Re: **US Eagle Credit Union - Academy**
5420 Academy Road NE
Traffic Circulation Layout
Engineer's Stamp 10-27-2021 (E18-D046)

Based upon the information provided in your submittal received 10-27-2021, the above referenced plan cannot be approved for Building Permit until the following comments are addressed:

**11 TYPICAL ACCESSIBLE SPACE SIGN**

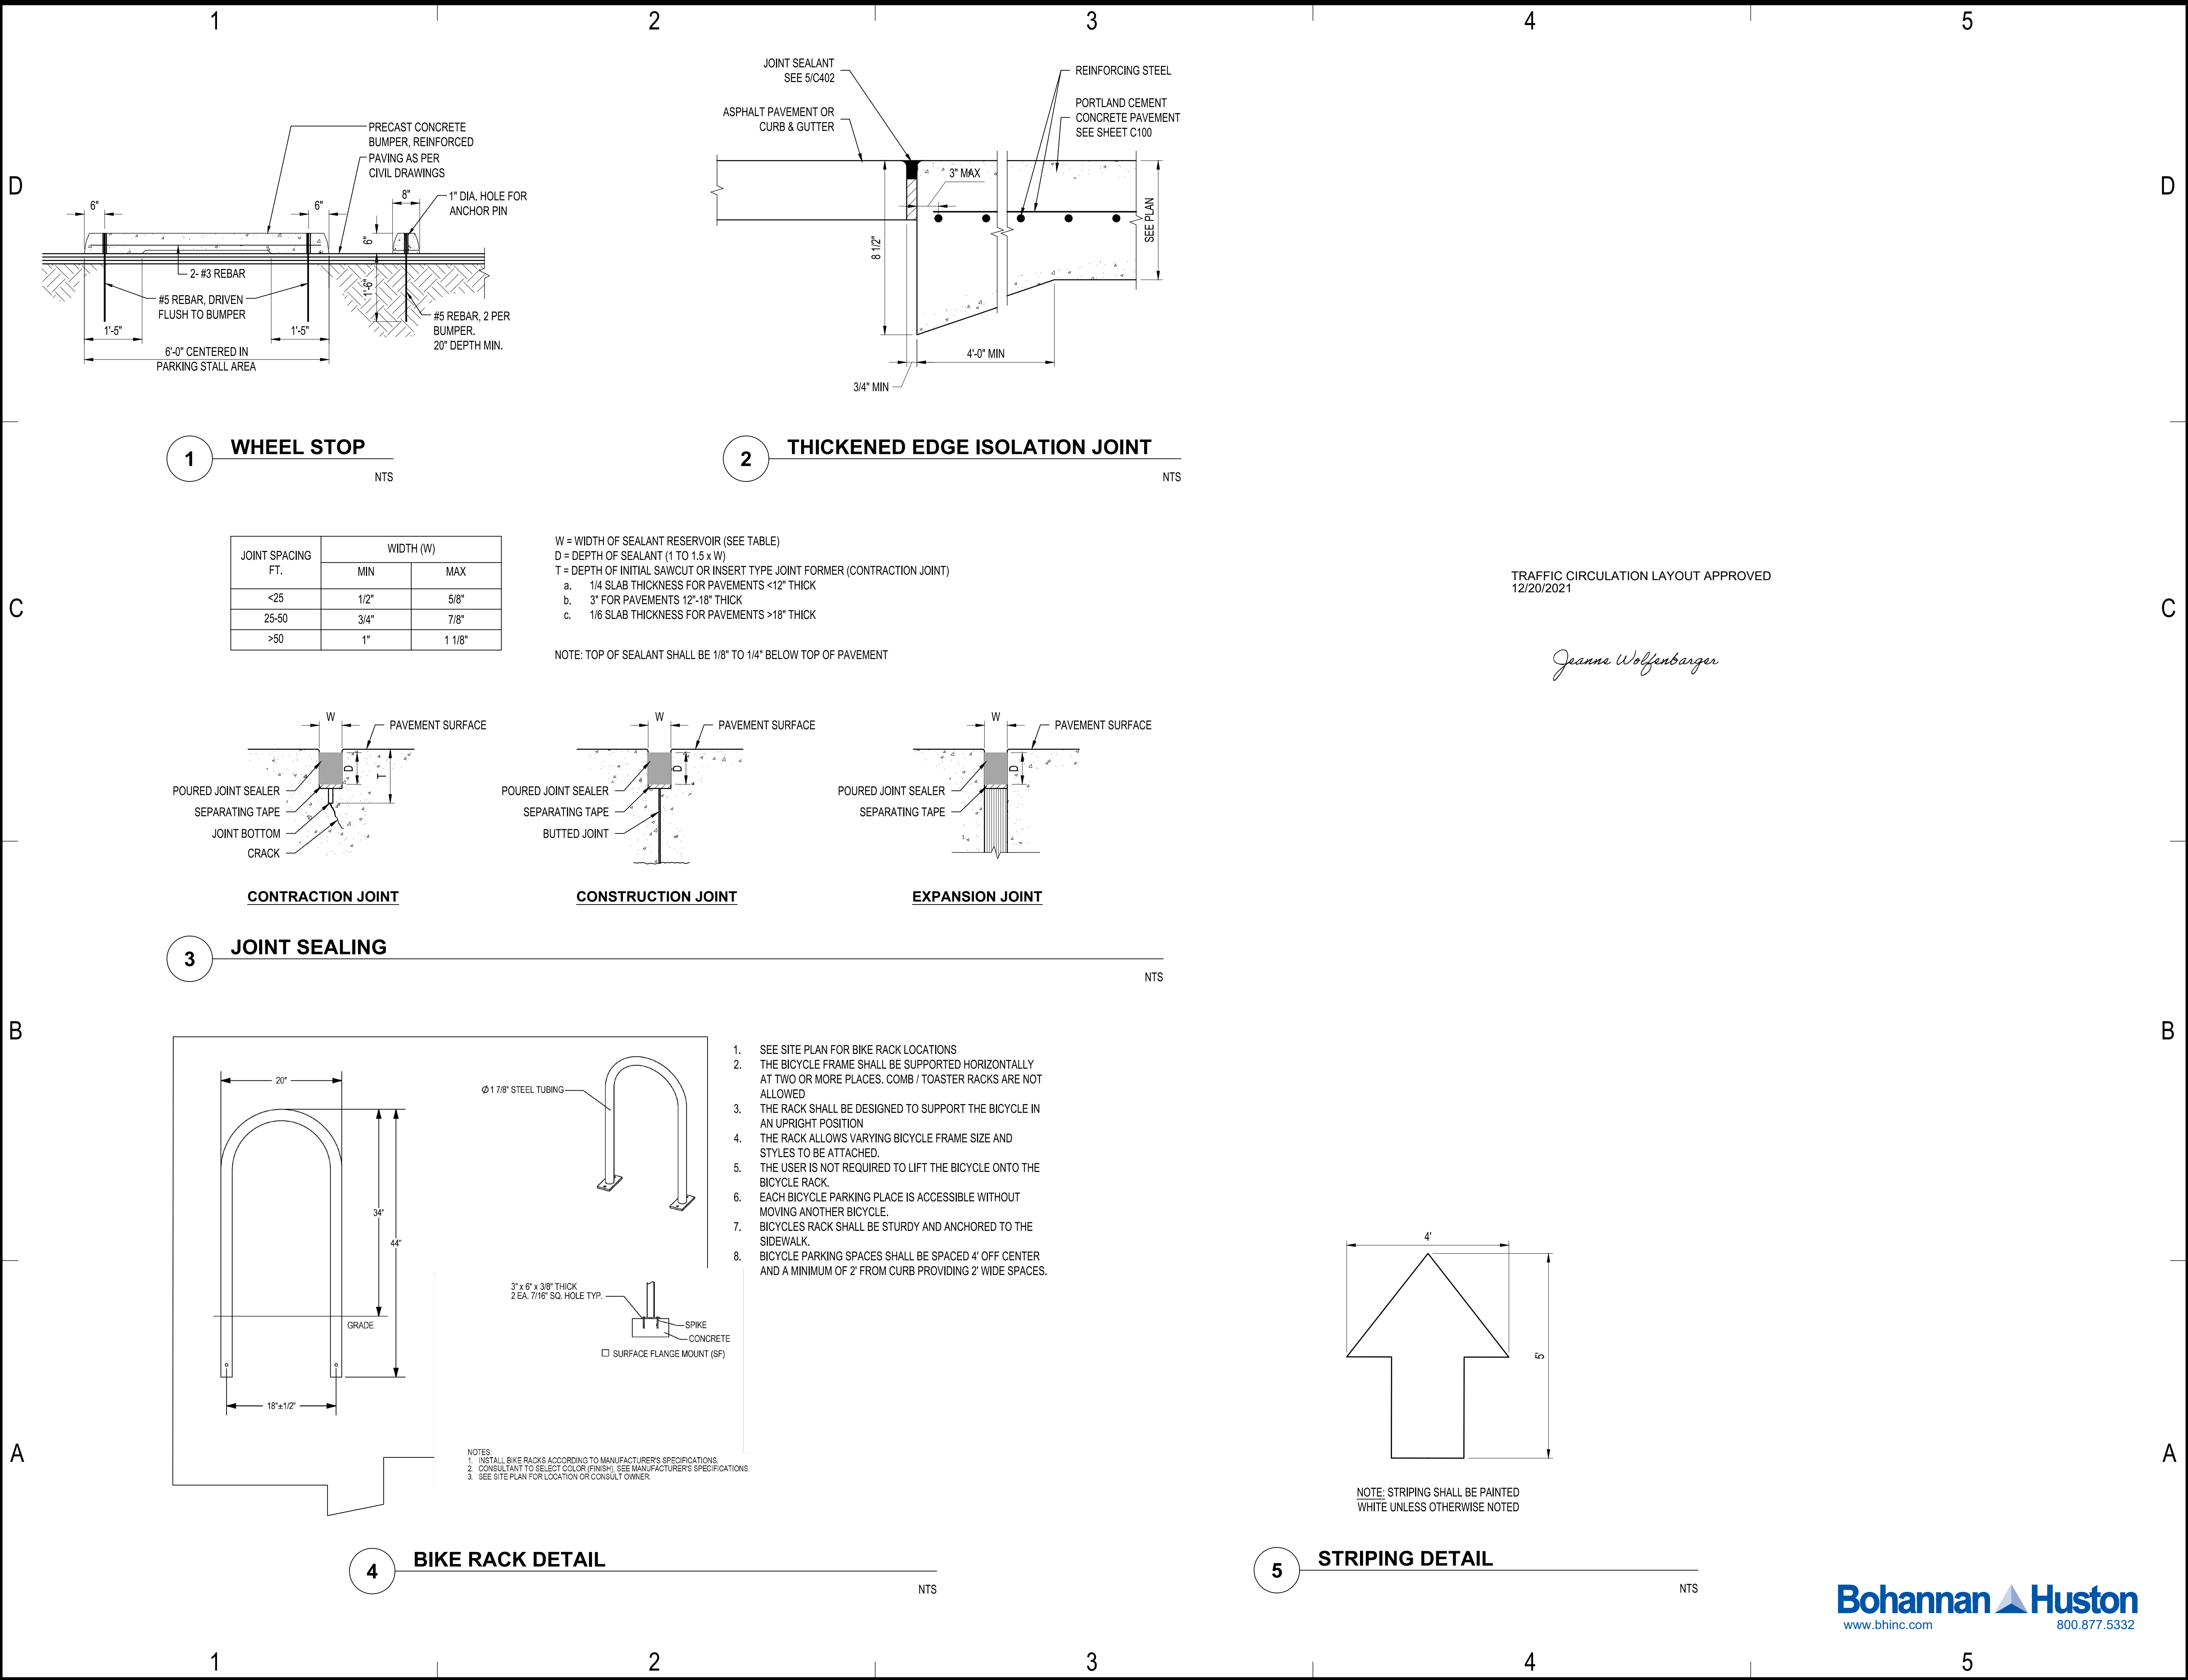
4. The ADA accessible parking sign must have the required language per 66-7-352.4C NMSA 1978 "Violators Are Subject to a Fine and/or Towing." Please call out detail and location of signs.
